Structural  
Engineering  
Consultants

August 29, 2024

In response to the inspector's comments, the following are acceptable changes to our construction documents:

2
S4 CEILING FRAMING PLAN
SCALE: 1/4" = 1'-0"

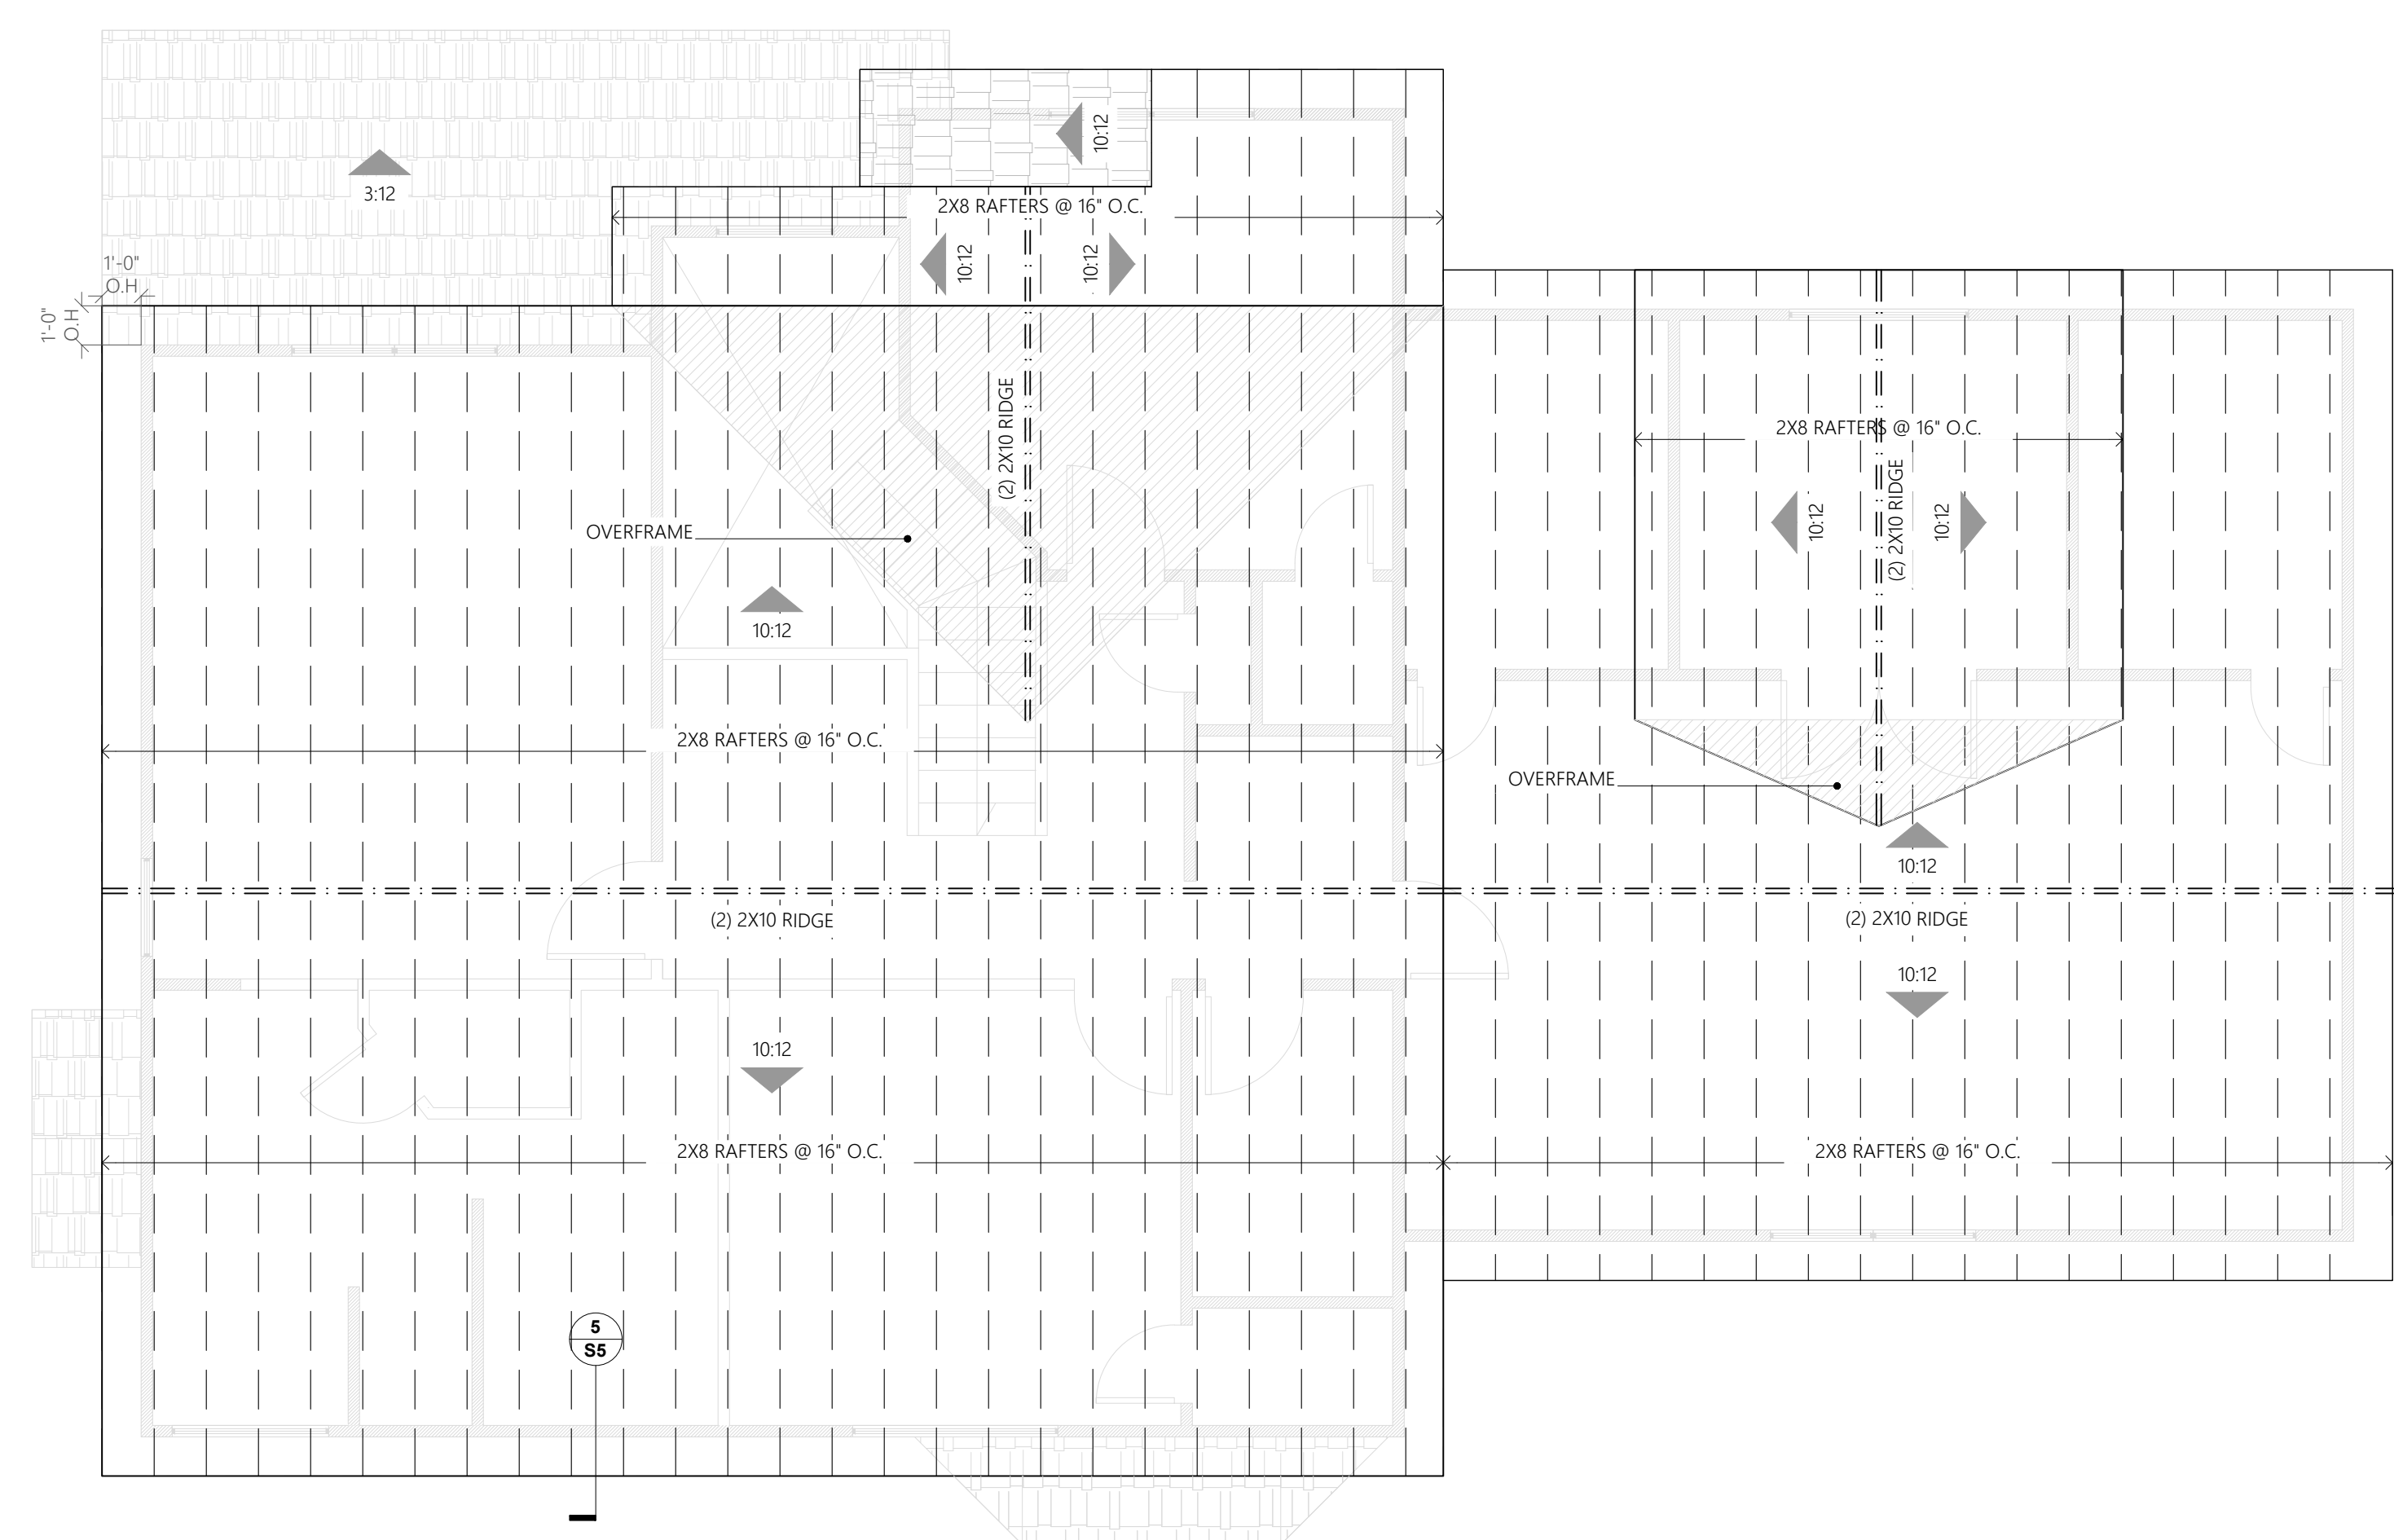
- The double (2) 1 $\frac{3}{4}$  x 11 7/8 LVL specified on the Ceiling Framing Plan 2/S4 is not required because there is load bearing wall below.
- The double (2) 1 $\frac{3}{4}$  x 14 LVL specified on the Ceiling Framing Plan 2/S4 is not required because there is load bearing wall below.
- The second-floor trusses are currently bearing  $\frac{3}{4}$ " on the load bearing wall along the center of the home. Attach two continuous (2) 2x4 to the existing double 2x4 wall top plate. This solution will provide a total 3  $\frac{3}{4}$ " bearing distance. The new double 2x4 shall be attached to the top plate with two (2) rows of 5" long Simpson Strong-Tie SDWS screws at 8" on center.
